Our Case Number: ACP-323849-25

Re: The proposed development is for a mixed use development that seeks the regeneration and adaptive reuse of a strategic brownfield site, as part of the Limerick City and County Council 'World Class Waterfront revitalisation and transformation project' 'Cleeves Riverside Quarter' in the townland of Farranshone More in Limerick City.

Formal Observation / Objection

Re: Proposed Development — Cleeves Riverside Quarter / Cleeves Riverside Campus

Job/Drawing No	Revision
CRQMP-FCBS-04-ZZ-DR-AA-0881 P01	
Cleeves Limerick	Status
SALESIANS-Proposed GA Elevations Block B

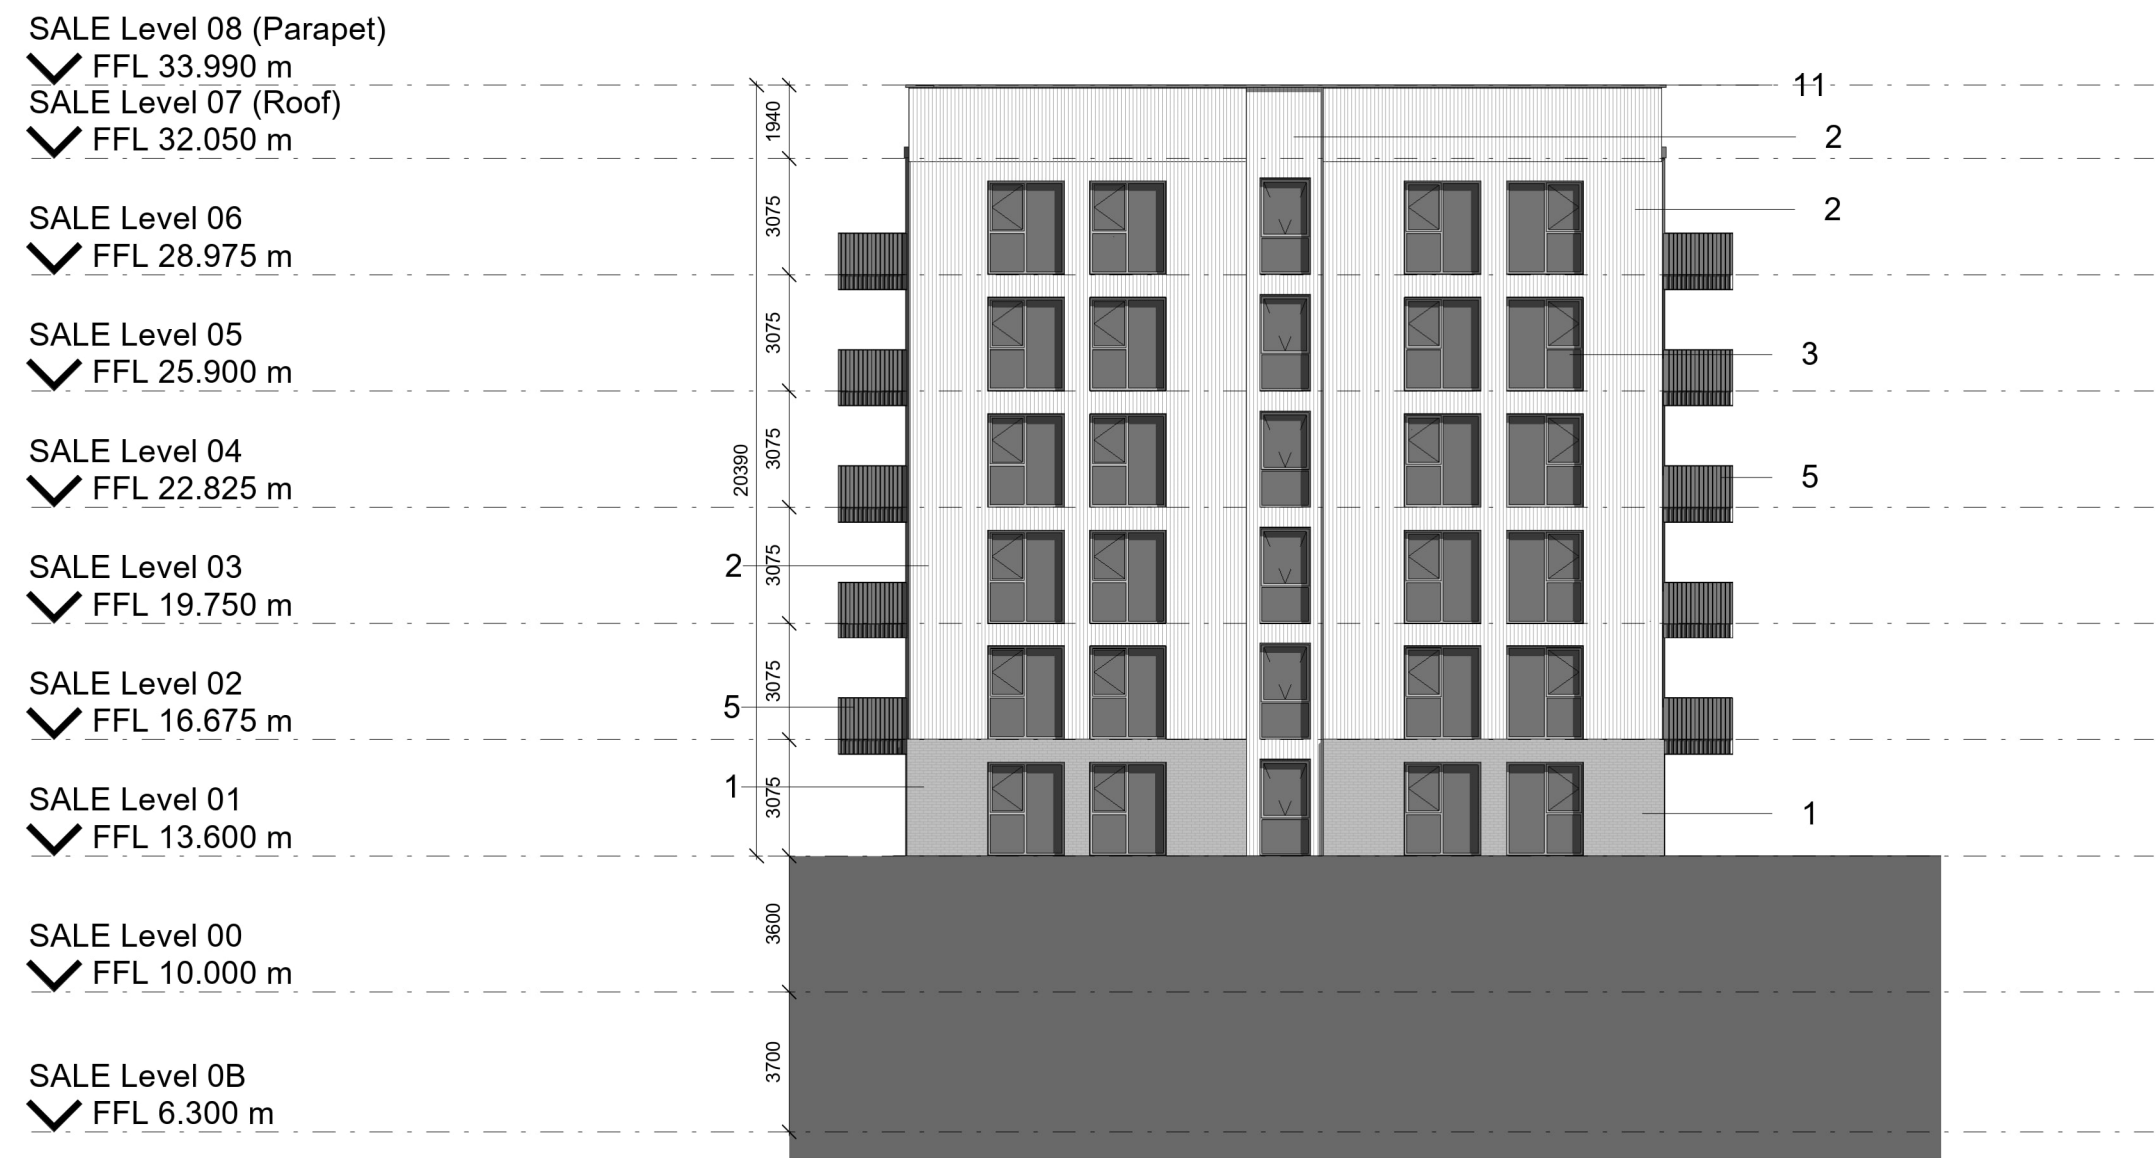
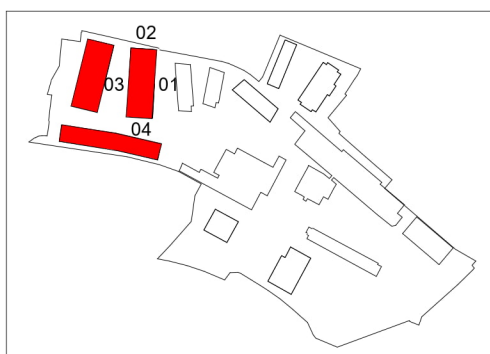
At 34meters, the tallest buildings proposed and the tallest in the vicinity are arranged in somewhat of a doughnut shape around the boundaries of the site.

The 34 meter Tower blocks on the Salesians site bear no relationship with the surrounding buildings in Mass or scale. The proposed tower blocks are simply enormous, dominating structures.

No attempt at screening or tapering up or down to neighbouring or existing structures is evident from the plans submitted and nothing appears on the CGIs that would suggest anything other than what I have described above.
